From: [REDACTED]
To: [REDACTED]
Sent: Monday, 25 March 2019, 13:54:25 GMT
Subject: FG/220/18

The latest report on this application states that there will be no change to the pond area and resubmitted plans show a clear area all round the pond.

Drawing Title **PROPOSED POND ACCESS
PLAN**

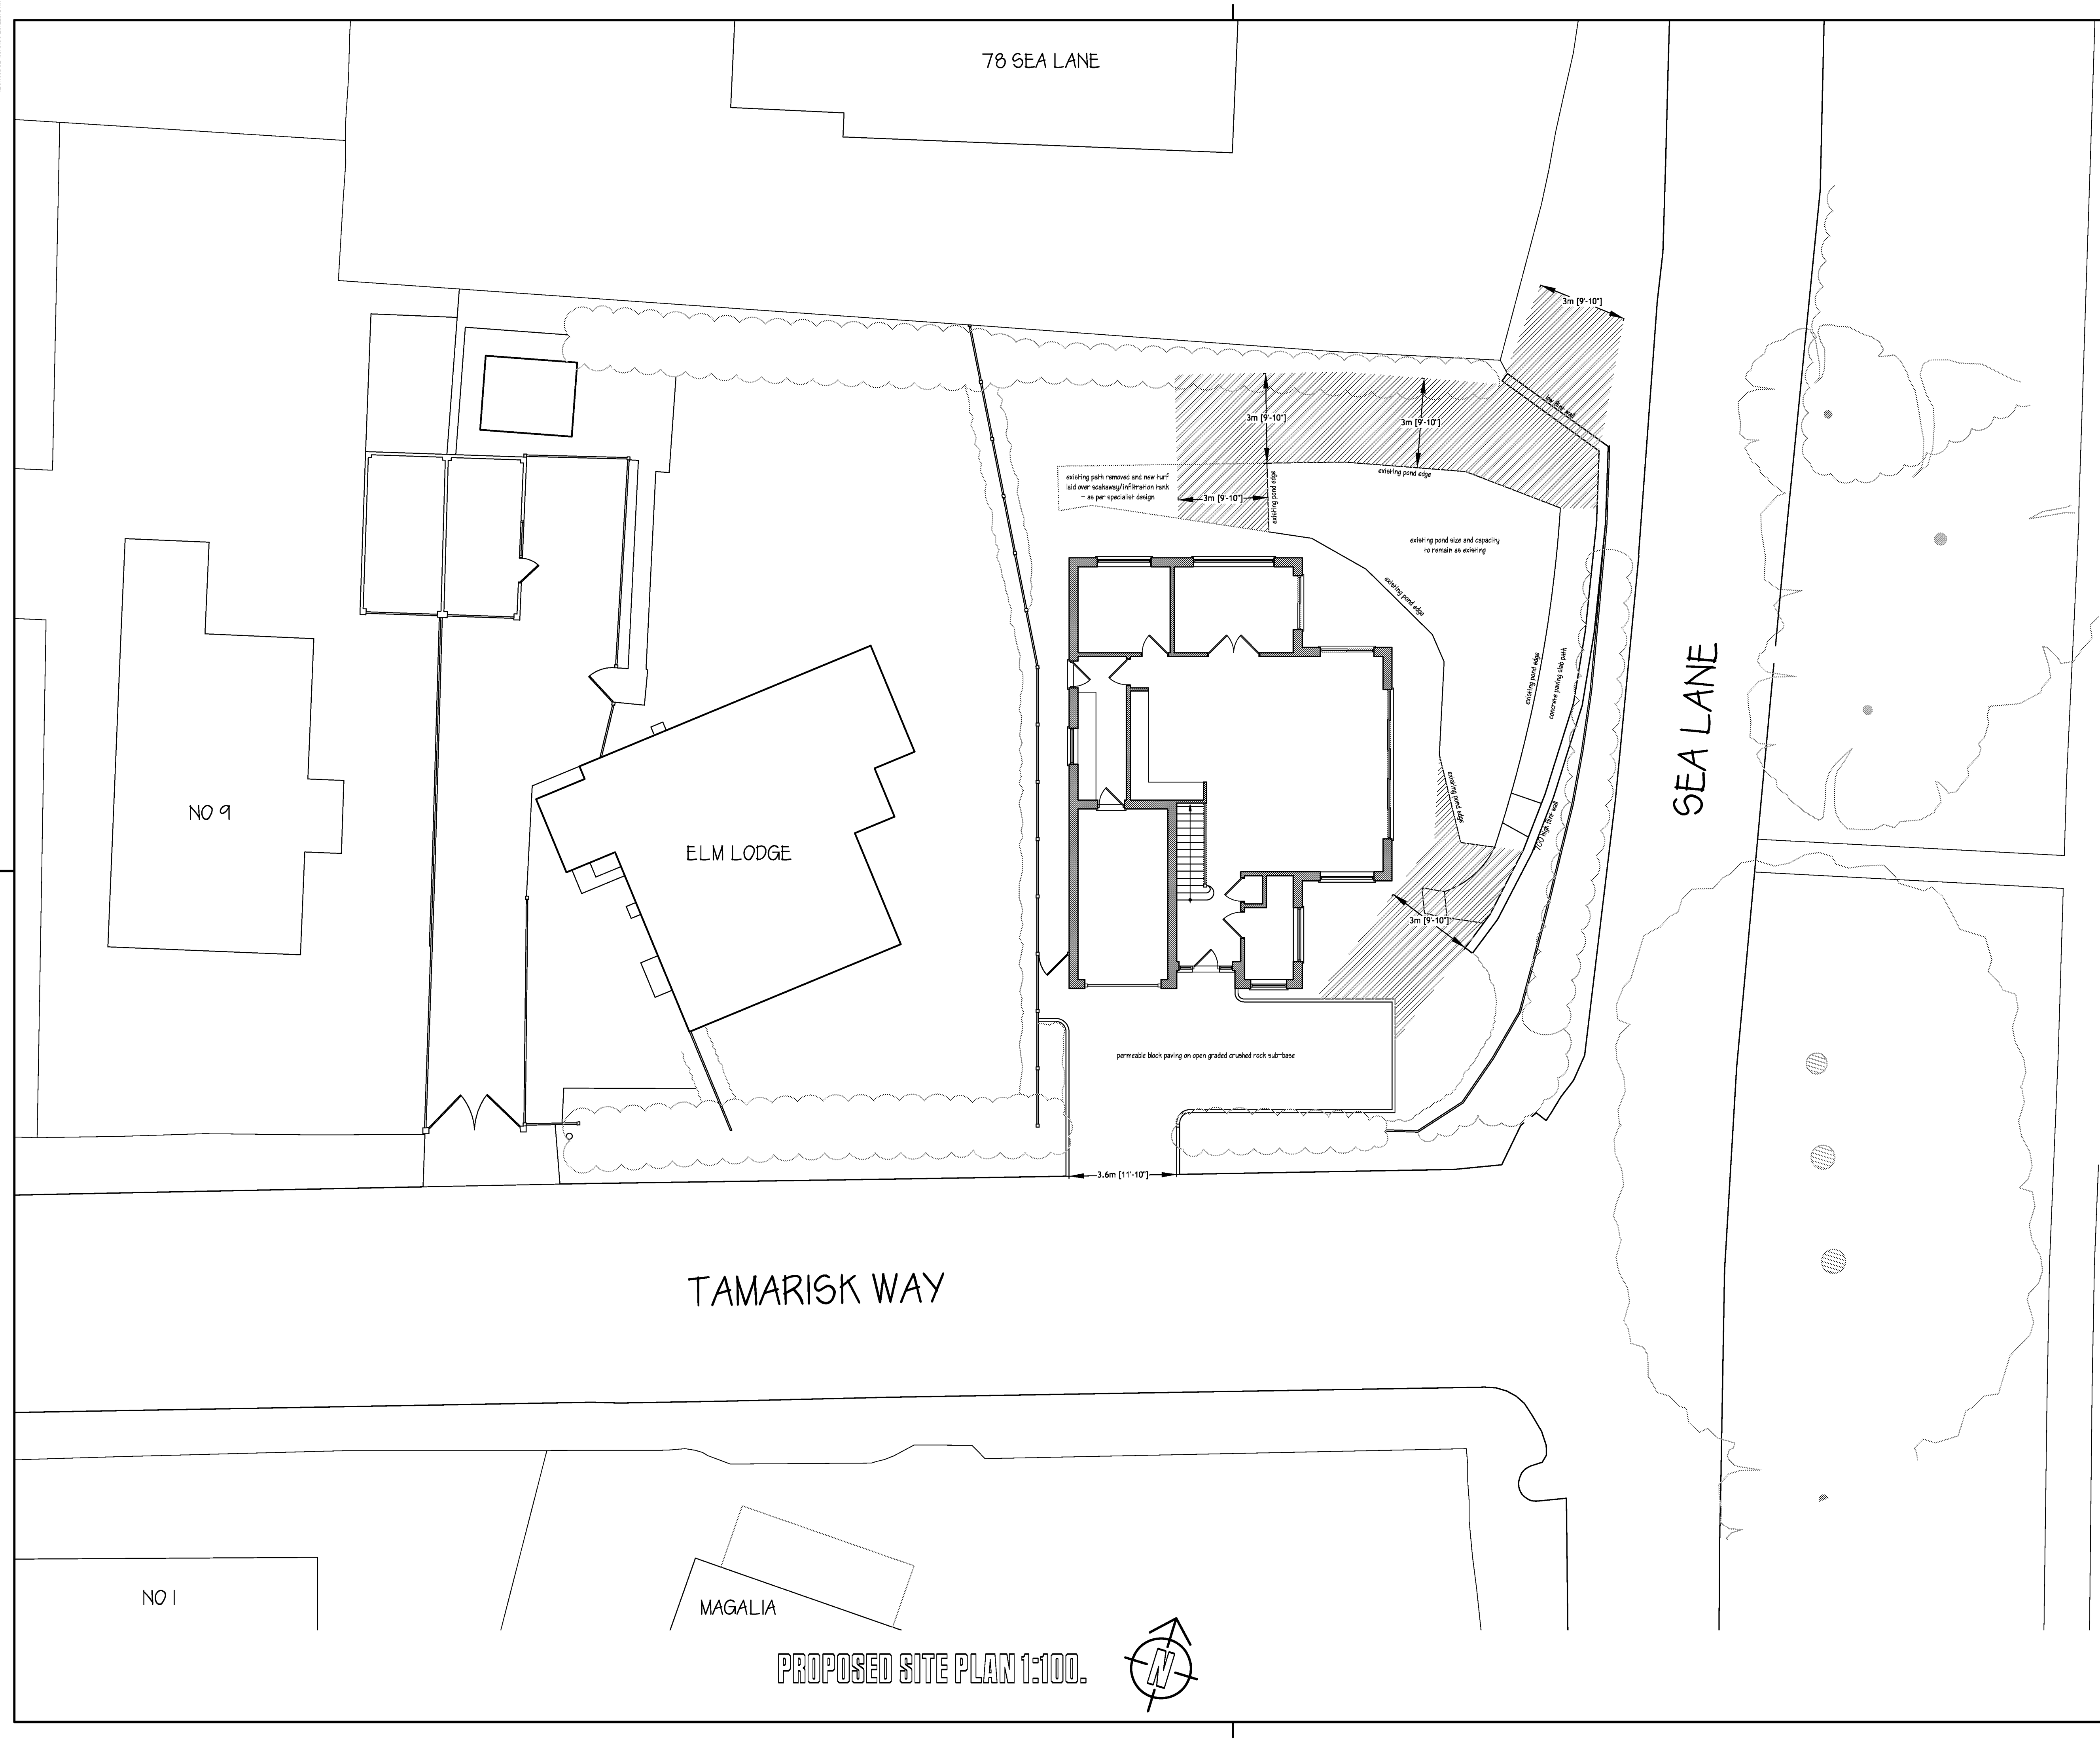
However, the pond area extends fully to the boundary wall on the NE corner of the plot, allowing no easement(ref Laura Gibbons report). The extent of the pond is clearly illustrated in the attached photos and on the land registry document already submitted. This further suggests that not withstanding small adjustments to the siting of the new building, there is no alleviation to the threat to the drainage system.
